**Application for a non-material amendment following a grant of planning permission.
Town and Country Planning Act 1990**

Erection of first floor side and rear extension, single storey rear extension and vehicular entrance gates (within a Conservation Area)

Minor change to roof pitch on front slope of proposed extension over the garage, in order to lower the ridge height. Roof pitch of this slope changed from 33 degs to approx. 26 degs

title plans & sections as proposed
 number 16026D-05-P01
 scale 1:50 or as shown
 size A1

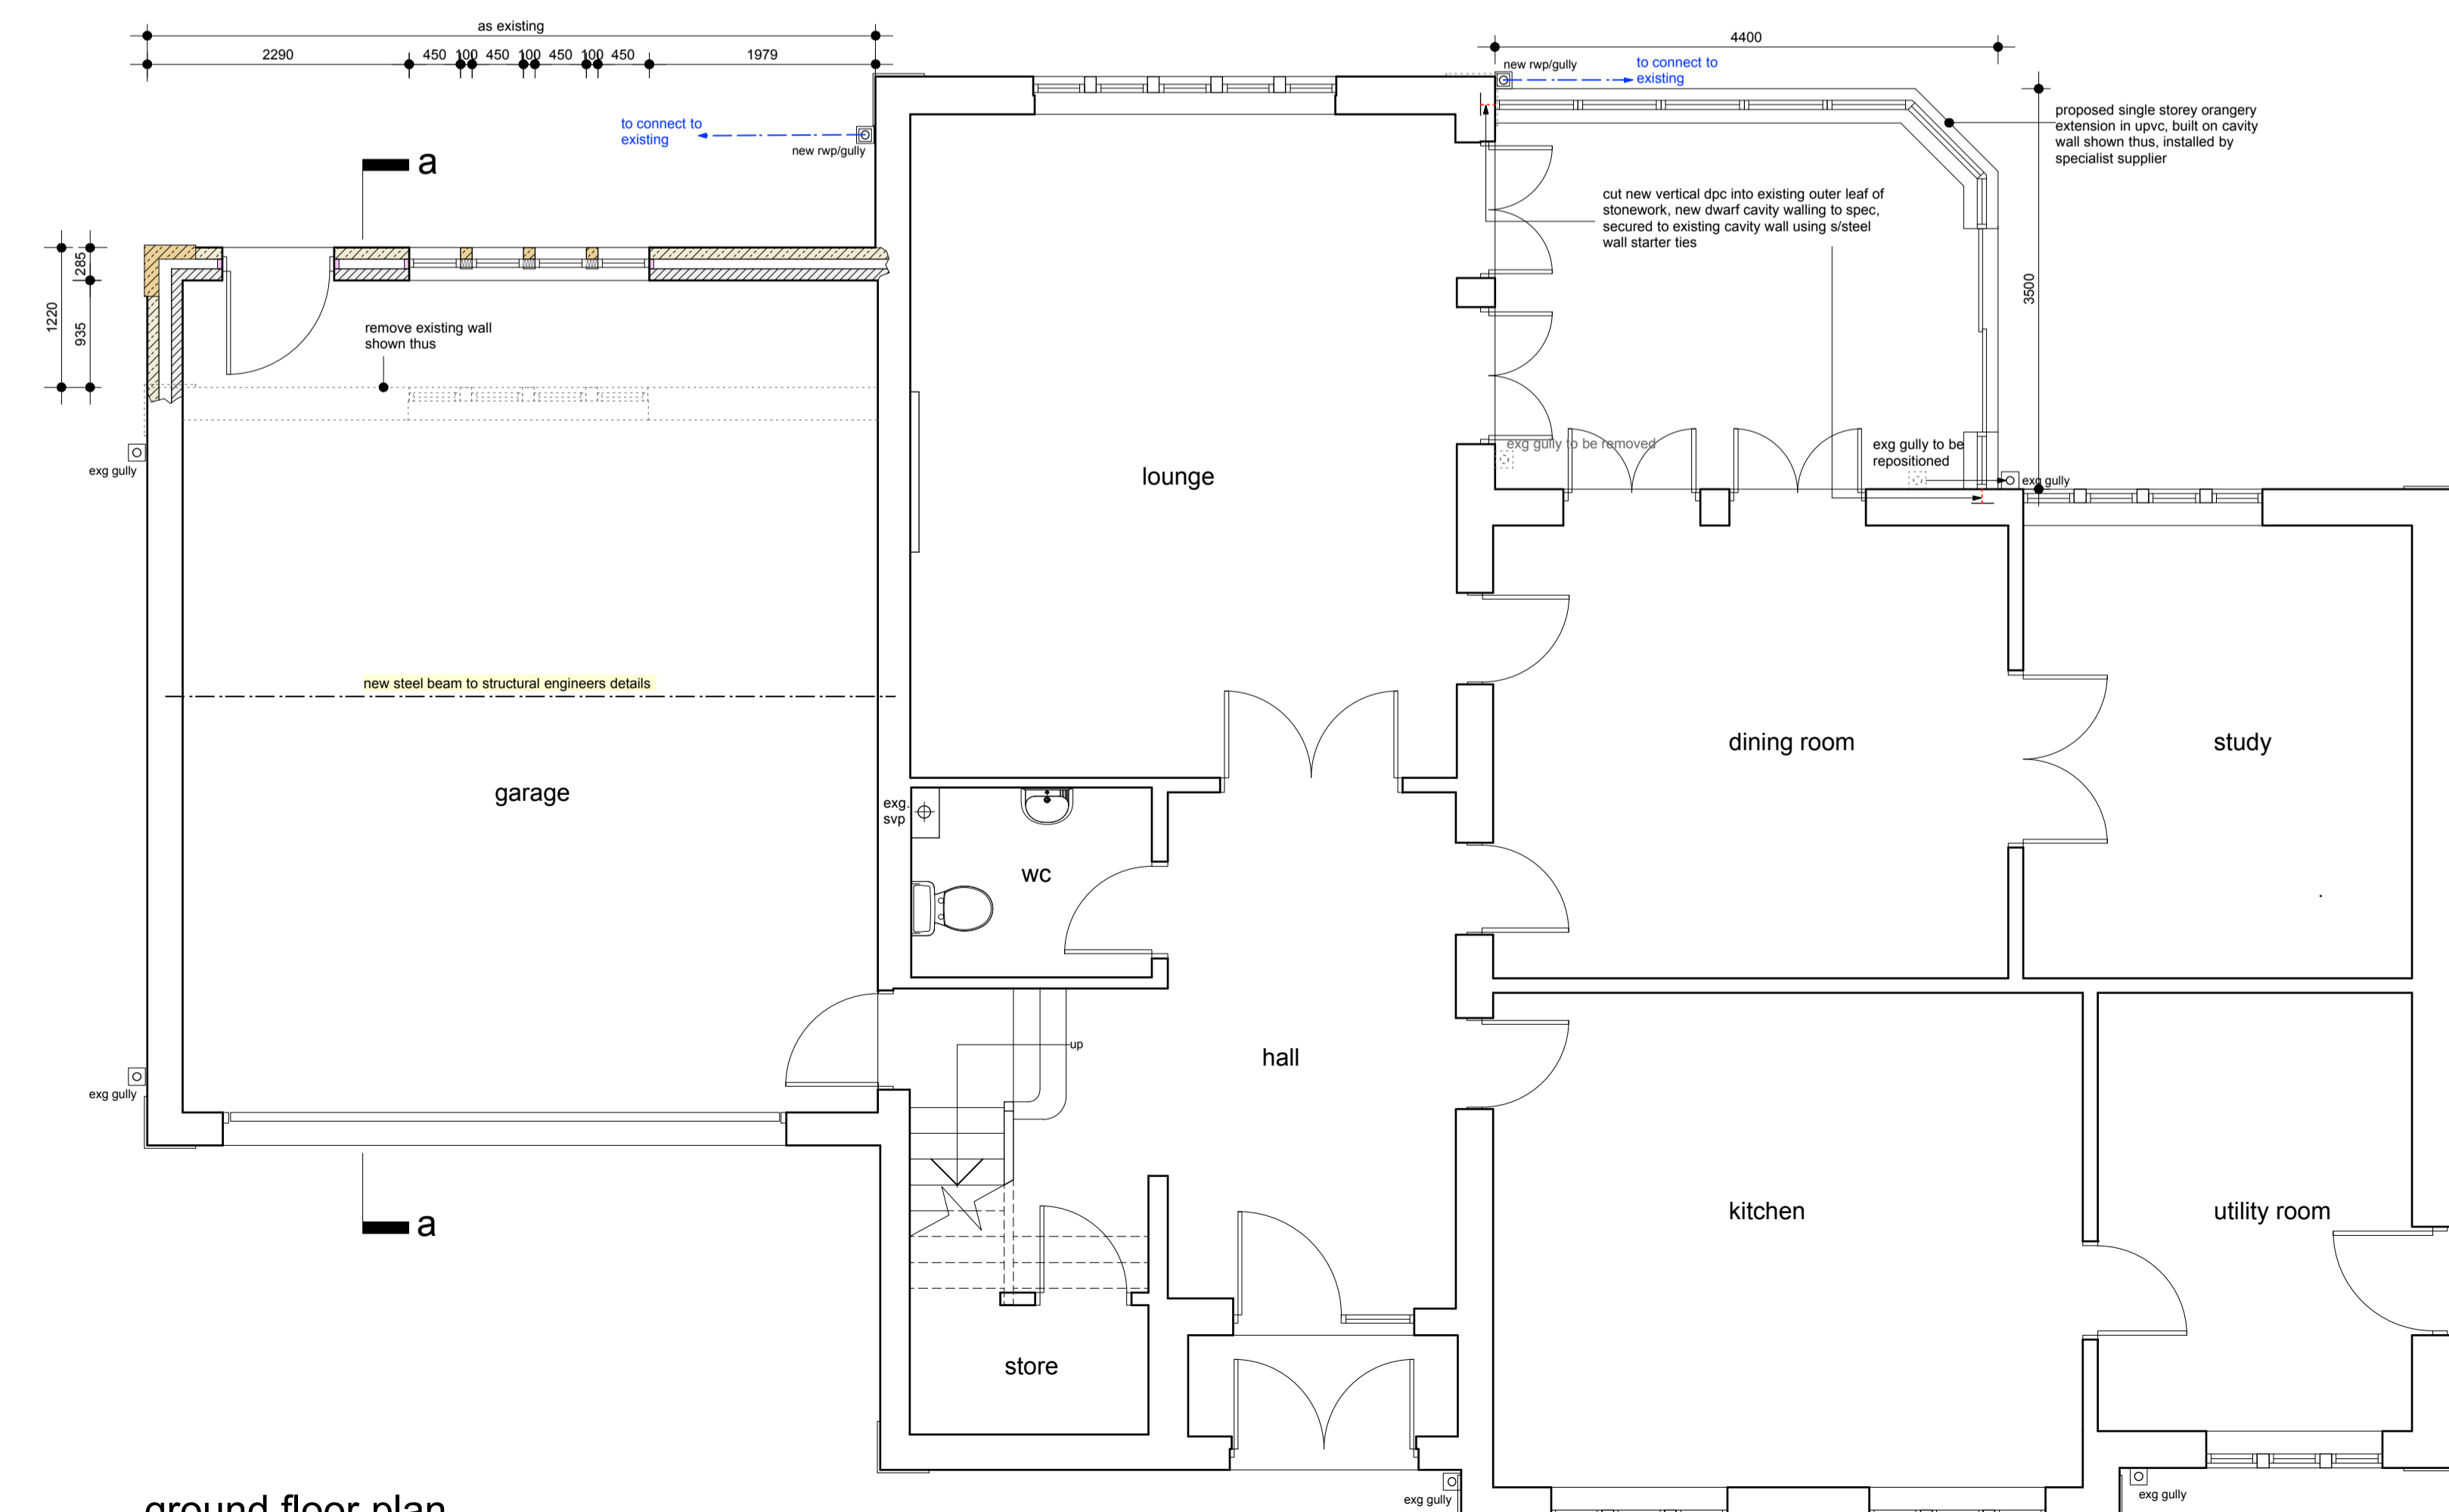
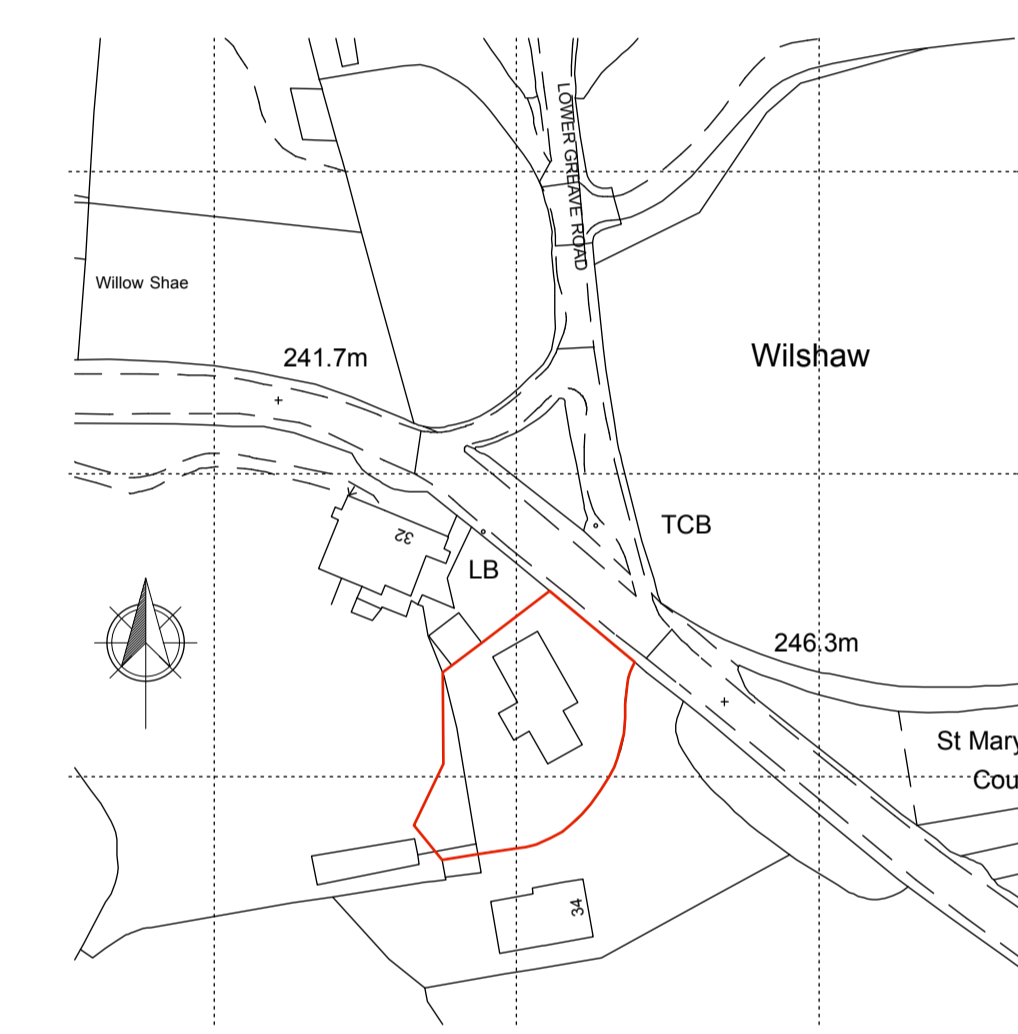
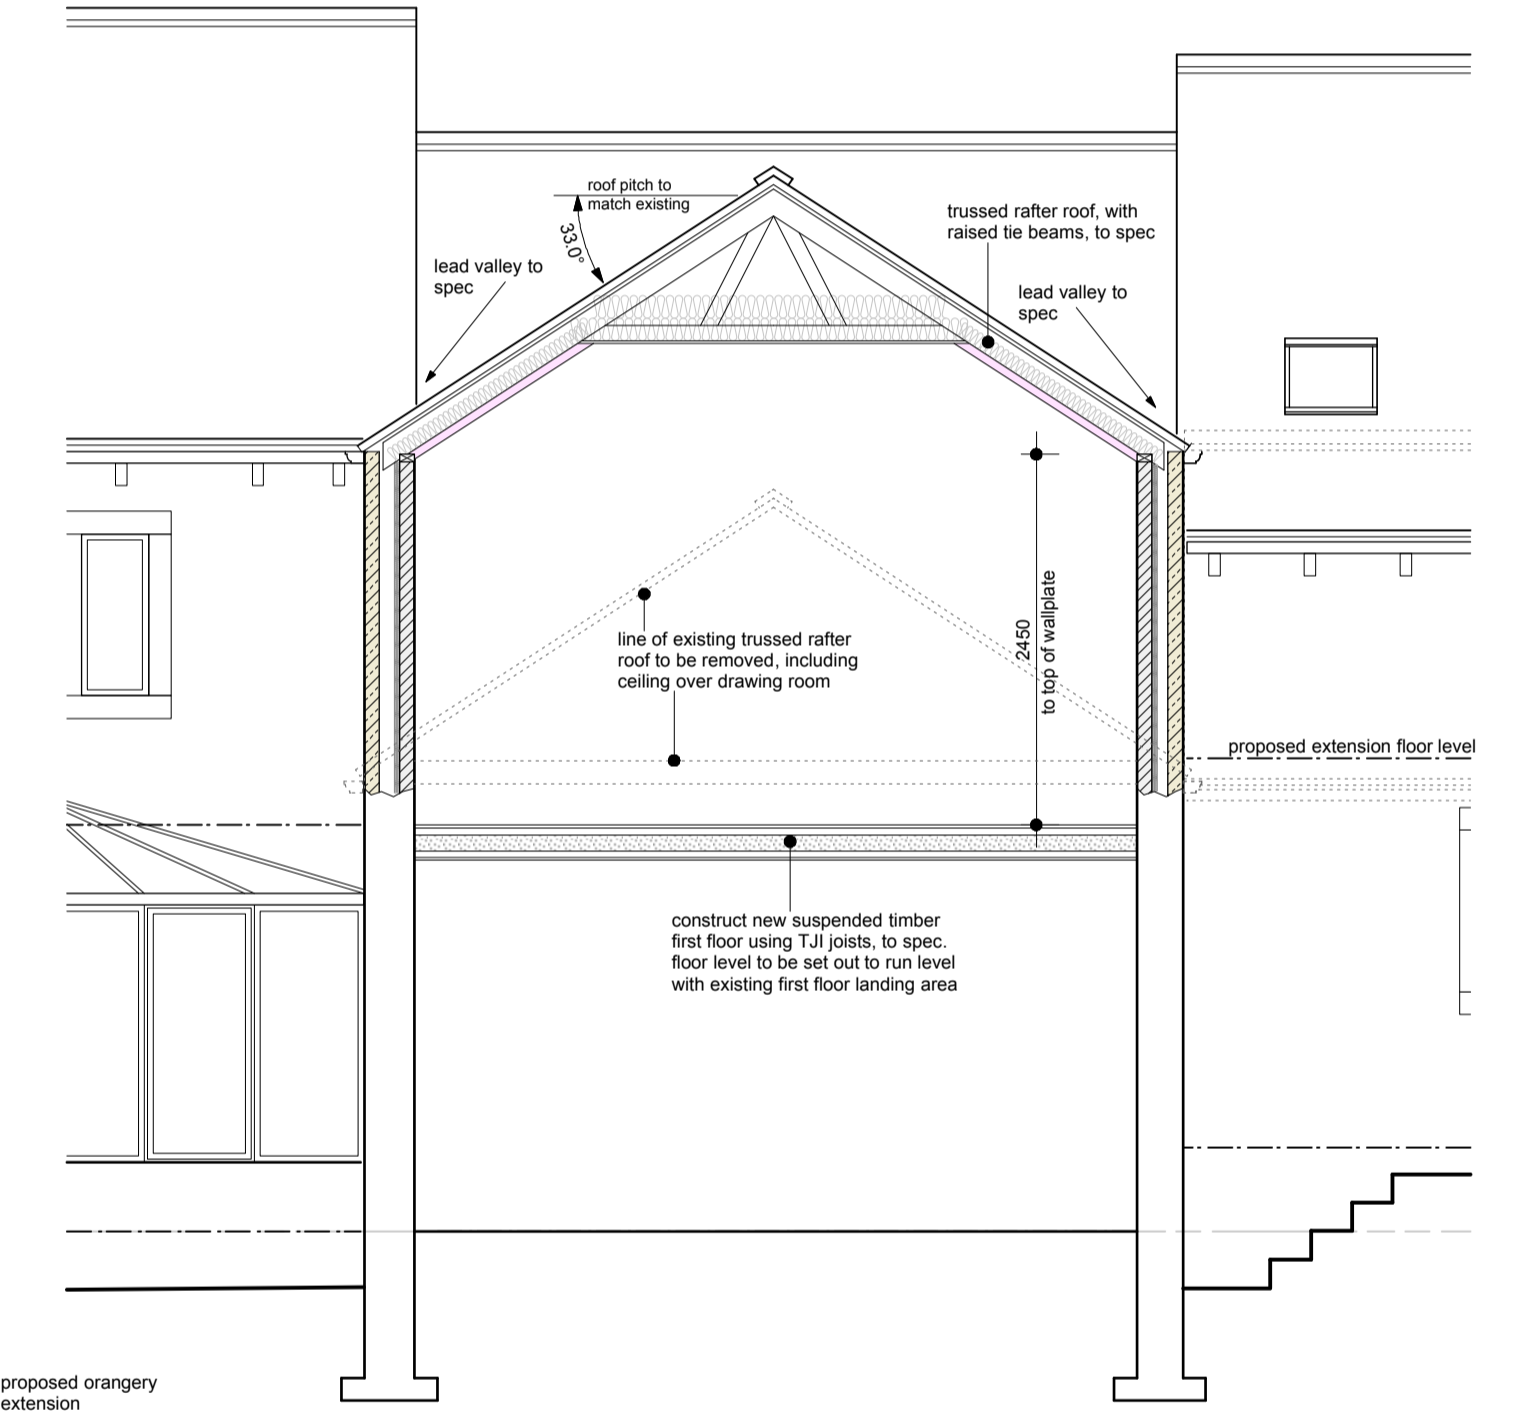
Having carried out a measured survey of the existing house, it was found that the existing information provided to us for the existing house was inaccurate and therefore the proposed ridge height would have been higher than that of the adjacent existing roof. The amendment seeks to keep the proposed ridge height no higher than that adjacent to it.
